Crystal Park Site 315R, CP-17-010

Please accept the following comments from El Paso County Public Health regarding the project referenced above:

A Site Plan
SP1 SCALE: 1" = 20'-0"

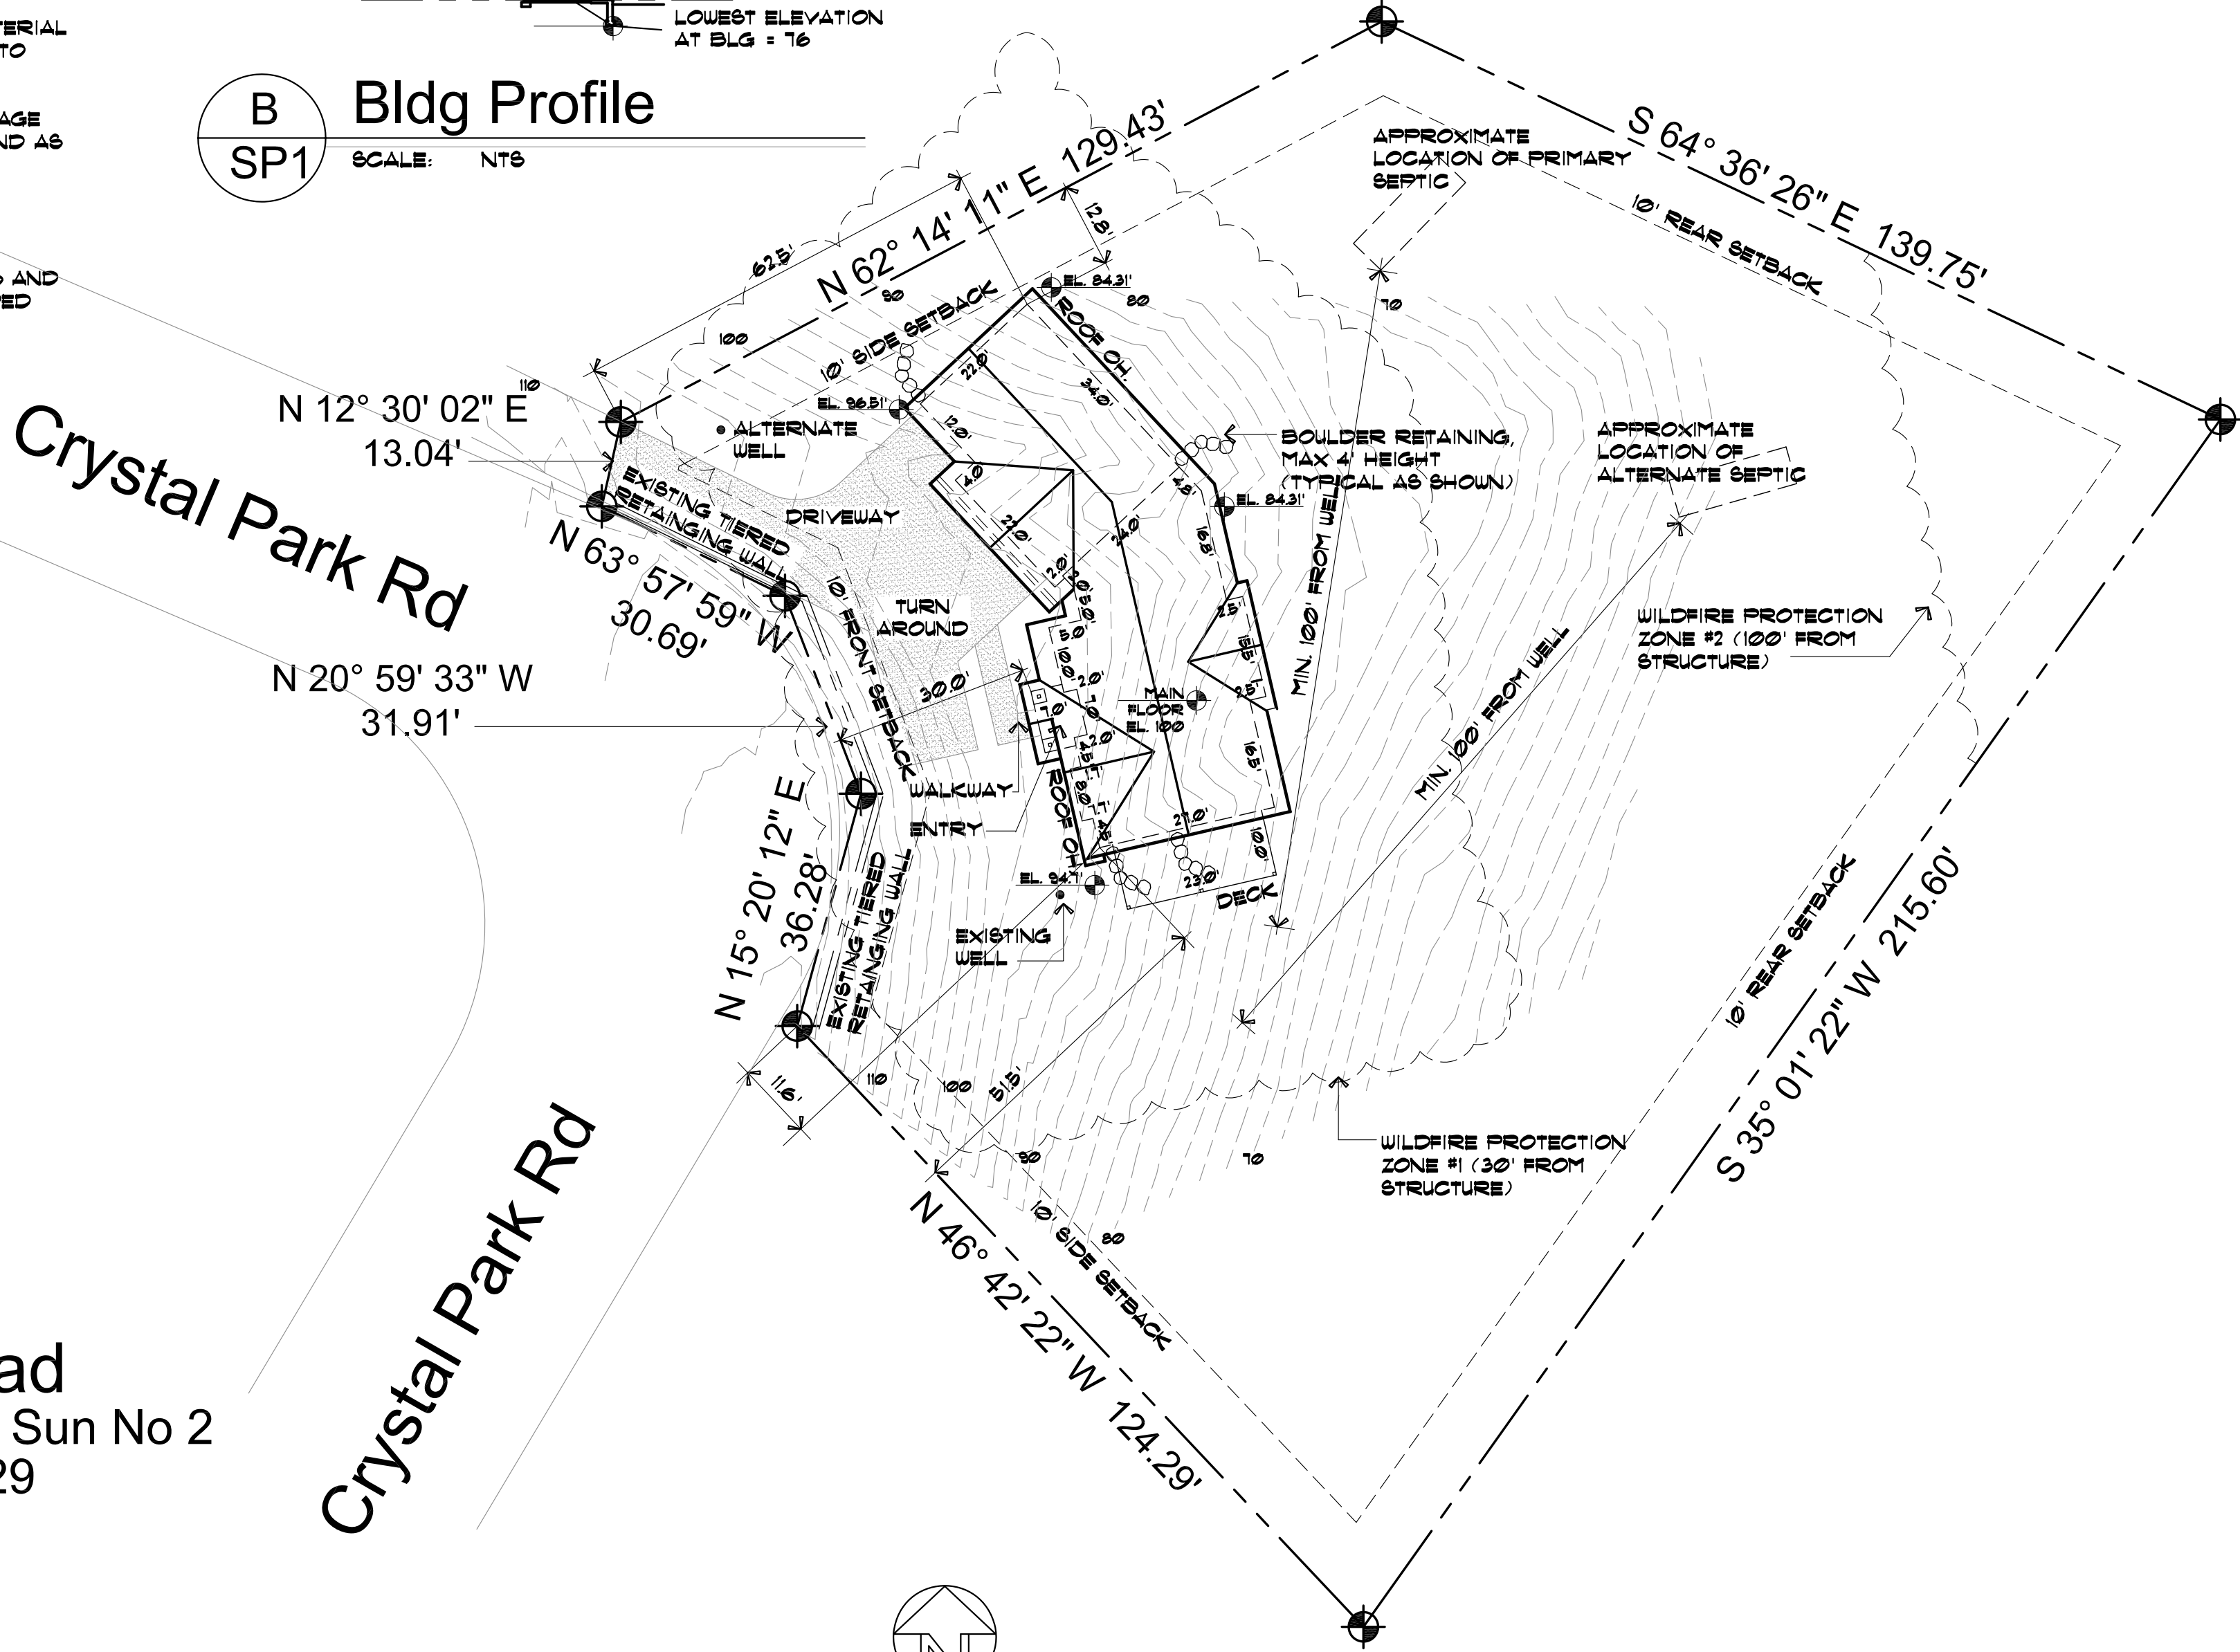
- **The site development plan indicates areas for both a primary soil treatment area (STA) site and an alternate STA. The OWTS must meet all current El Paso County Public Health OWTS Regulations. Please be aware that a vertical STA or “seepage pit or drywell” is the last type of STA to be considered for approval. The results of the soil test in these areas will determine the types of STA’s to be considered for approval.**

- **The STA’s must be 100’ minimum from any well, internal or external, and also must be protected from all house construction and site development activities. Compaction of the STA by such activities may cause the area to be unsuitable for use. Recommend fencing the area during construction to minimize the potential for soil compaction. Adjacent property well locations were not shown on the Site Plan; therefore, be aware of the specific 100’ setback requirements.**
